NOTICE TO CONTRACTOR
 All construction must comply with current NC Building Code and is subject to field inspection and verification.

APPROVED
 Limited liability only review
 Permit holder responsible for full compliance with the code

PLAN INDEX
 CL 3145

Front & Rear Elevation

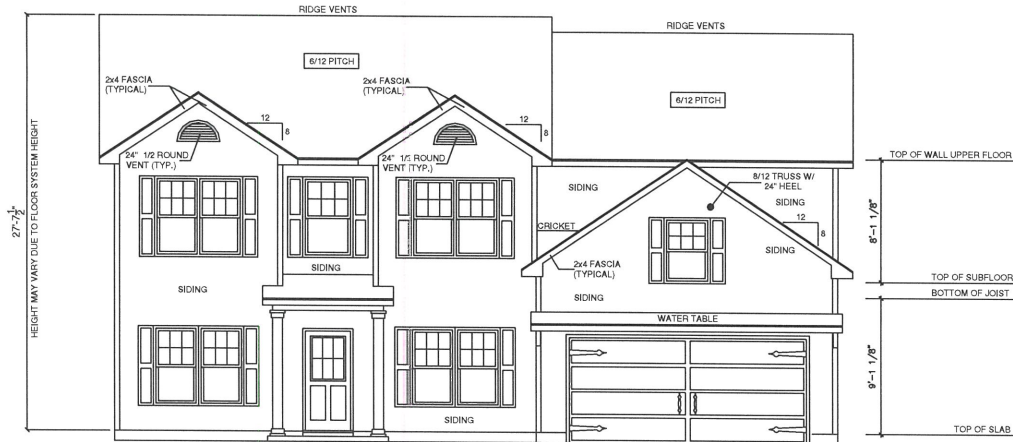
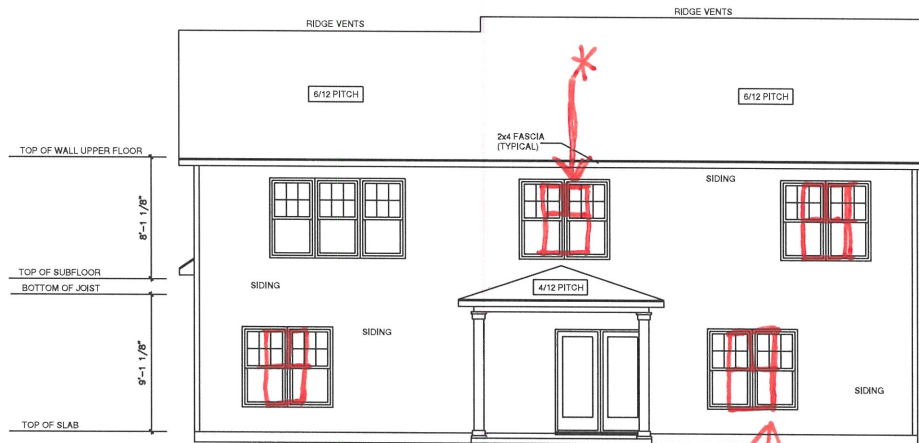
* Add window back in
 for Creekwood Farms

Right & Left Elevation

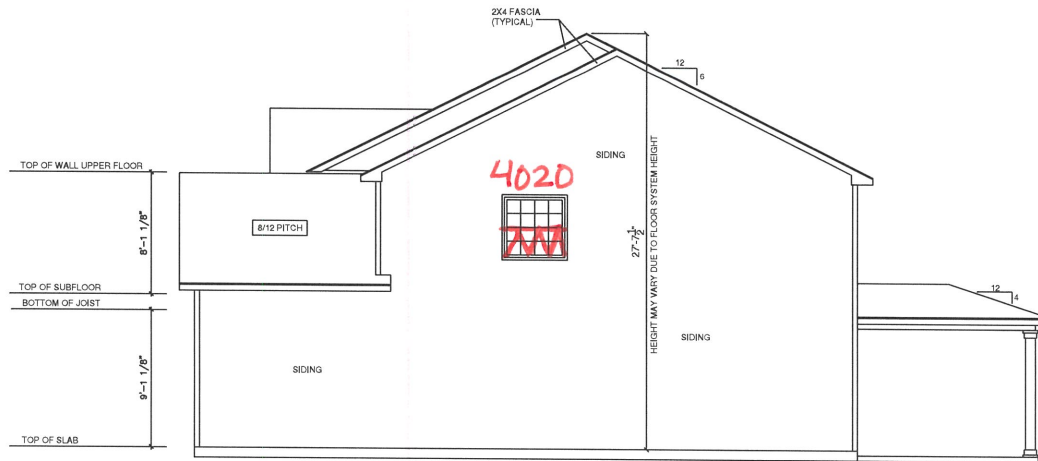
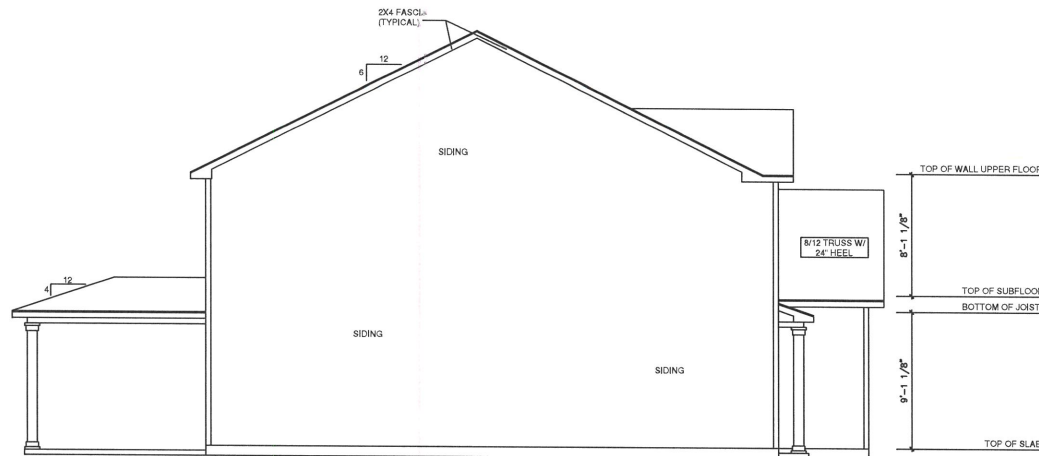
*add window back in for Creekwood Farms

FIRST FLOOR PLAN
SCALE: 1/8" = 1'-0"

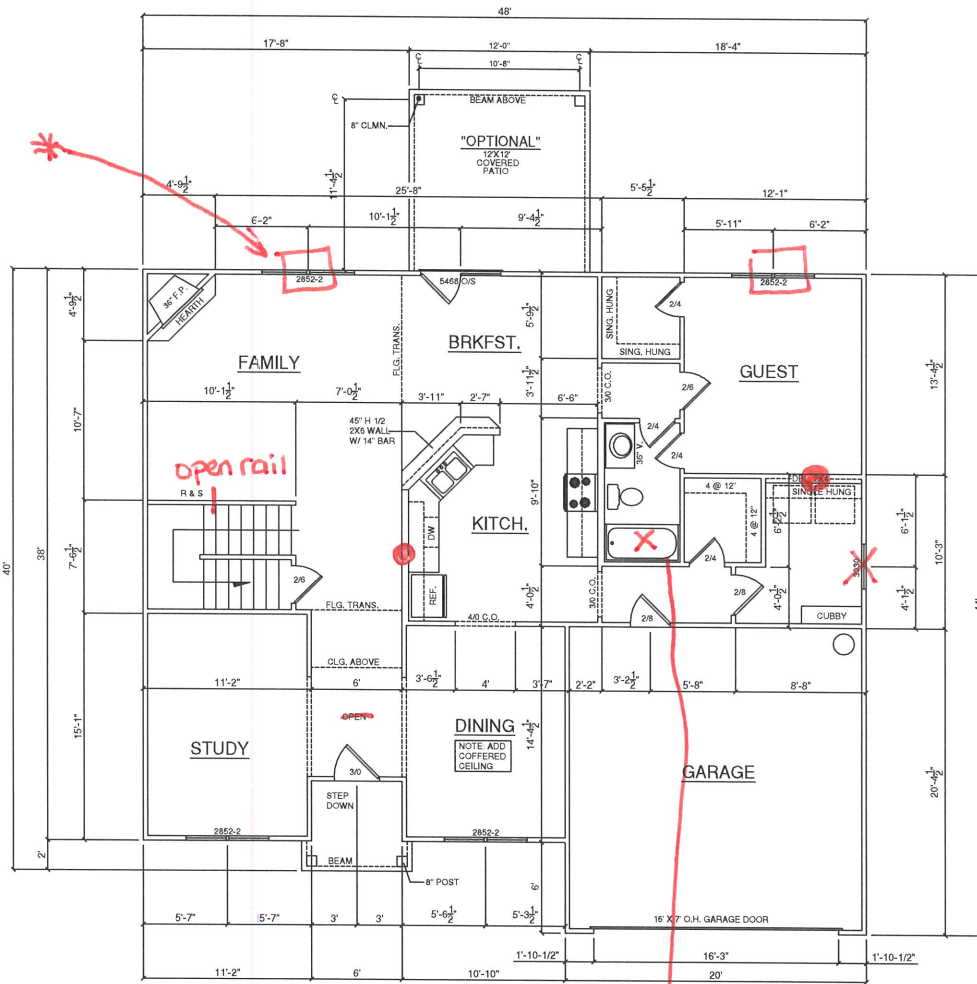
● Plumbing drop

SECOND FLOOR PLAN
SCALE: 1/8" = 1'-0"

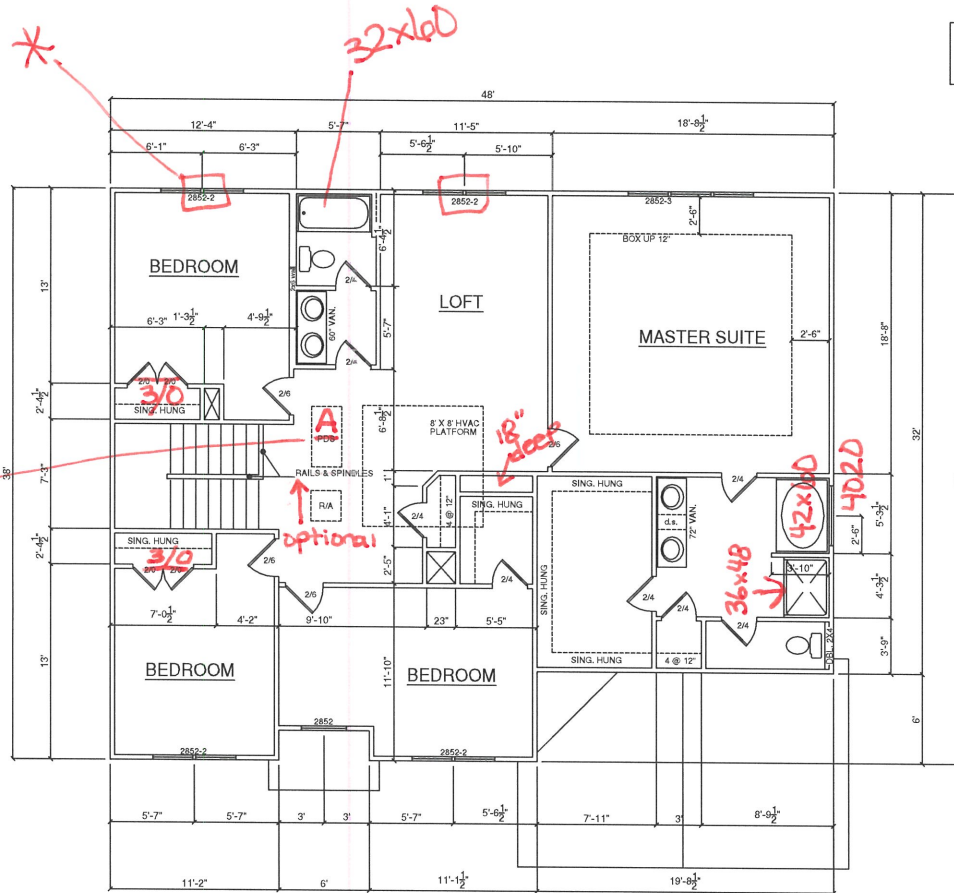
36x60 Shower only

*add back in for Creekwood Farms

move Access
down. Center
on platform
